26 February, 2013

The Director General
Department of Planning
23-33 Bridge Street
Sydney, 2000

Southlands Remediation and Development Project – Modification under S.75W of Project Approval - 06_0191 – Reconfiguration of Compensatory Flood Storage Basin, Reconfiguration of Lots 7, 8 and 9, Reconfiguration of Lots 3-6 Boundary, Addition of wording requested by OEH Accredited Site Auditor

Southlands Industrial Estate 22 February 2013 **Figure D9a**
Final Development Scenario 50% AEP flood level difference map

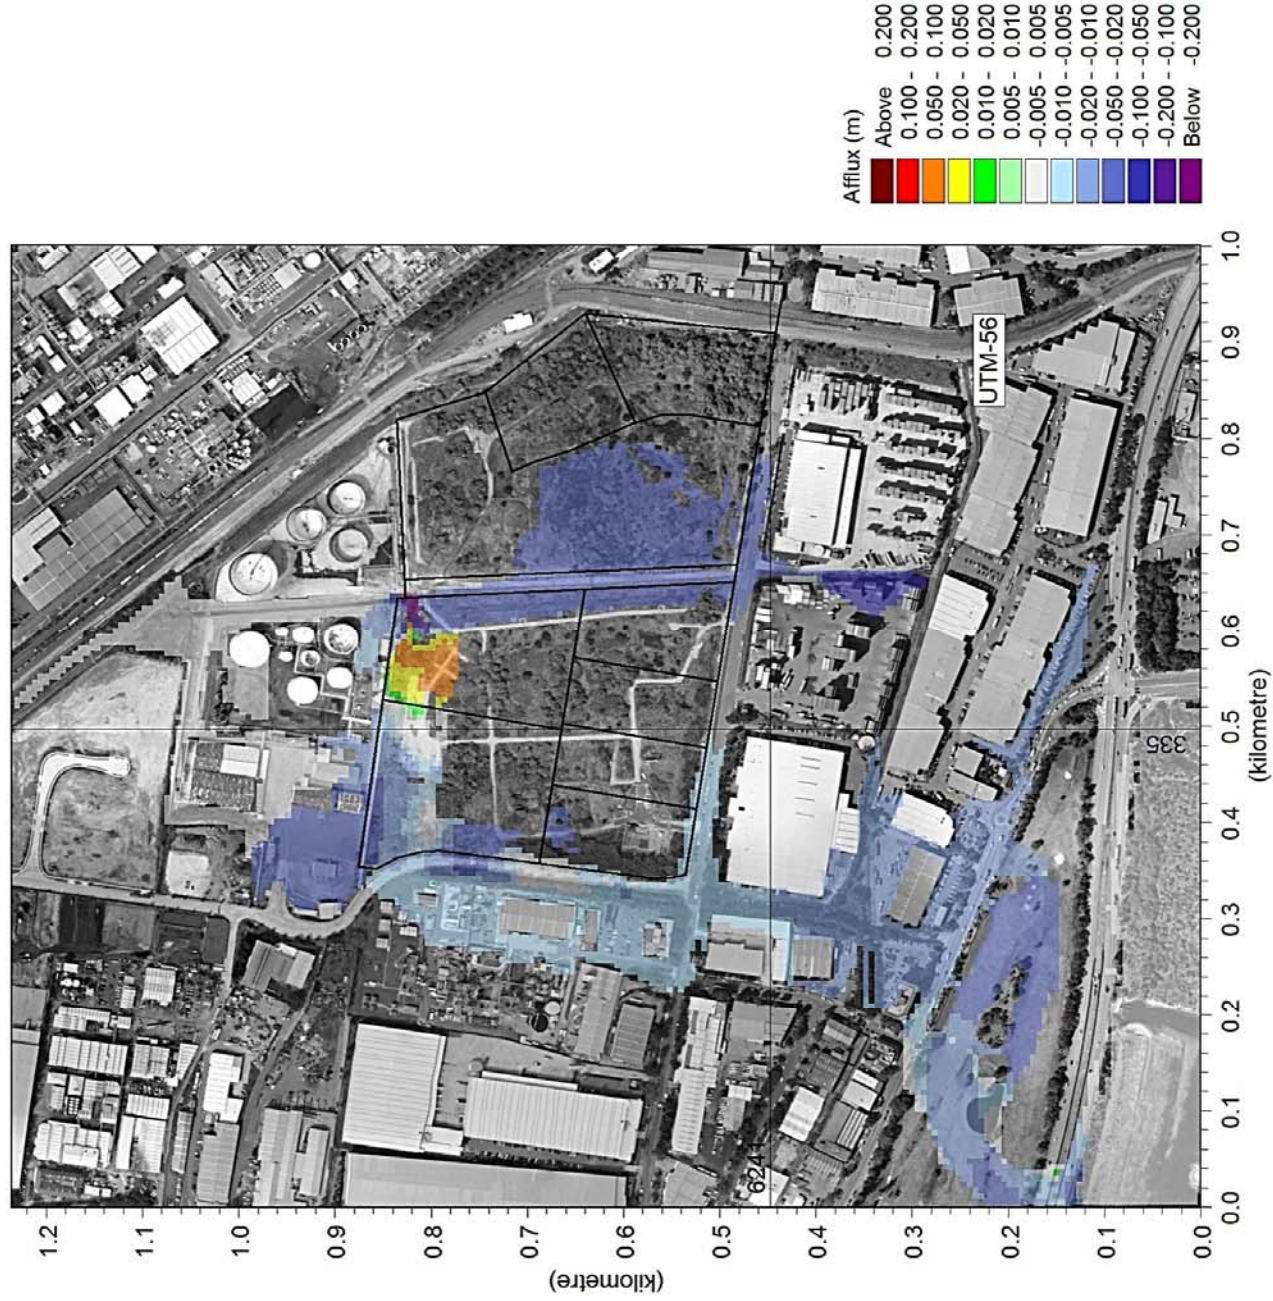
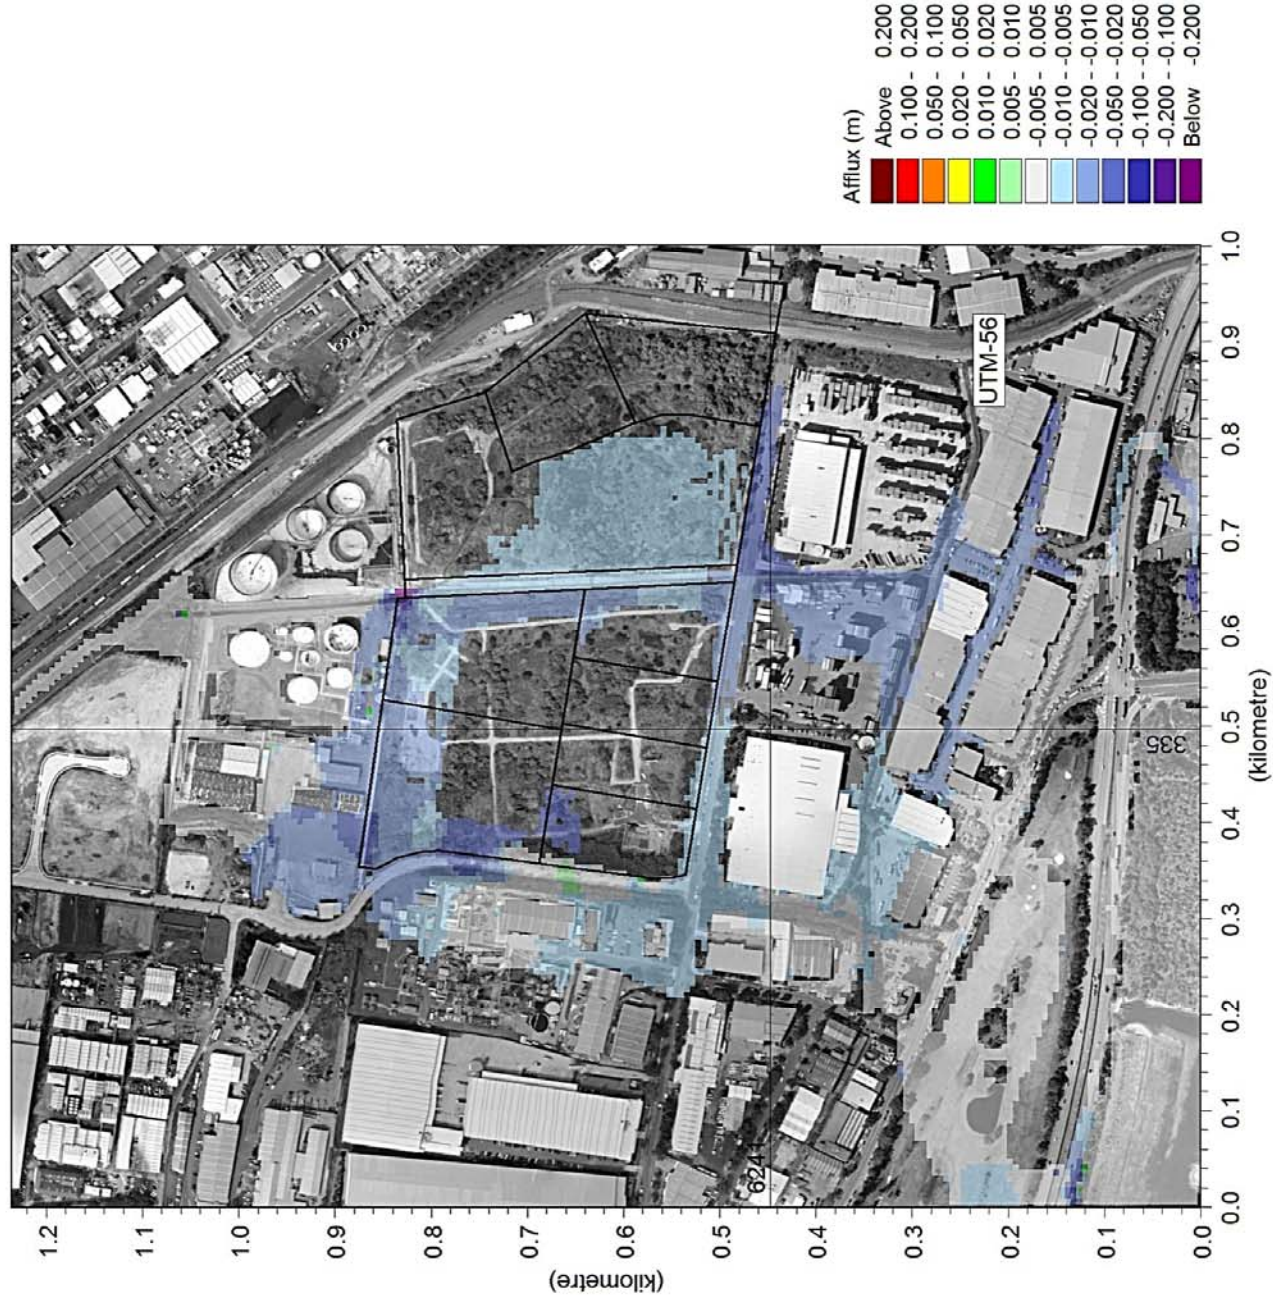
Their advice (*Southlands – Detailed Design 2D Flood Re-Modelling – Addendum Advice Regarding Variation to Compensatory Flood Basin Design and Impact, Aurecon Letter to Orica, Dated 25 January 2013*) concludes with the reproduction of updated diagrams for the flood impact demonstrated in the difference diagrams (flooding impacts from the existing situation) for the 2 year, 10 year and 100 year events. (Revised diagrams D9a, D10a and D11a)

- a) *be constructed **as required to the east and west** of Springvale Drain and immediately upstream of McPherson Street;*
- b) *include a control structure on the Springvale Drain to control flows into the detention basin;*
- c) *~~include a low flow pipe to allow draining of the detention basin;~~ (Note, this is no longer required as the basin level is now generally matching the Nant Street levels)*
- d) *be constructed in accordance with the report Orica Southlands Remediation and Development Project Hydraulic Modelling Report and Response to Exhibition Submissions/Comments – (Report Ref: 204617, 29th November 2010, Revision 3 by Aurecon, **as amended by Southlands – Detailed Design 2D Flood Re-Modelling – Addendum Advice Regarding Variation to Compensatory Flood Basin Design and Impact, Aurecon Letter to Orica, Dated 25 January 2013**); and*
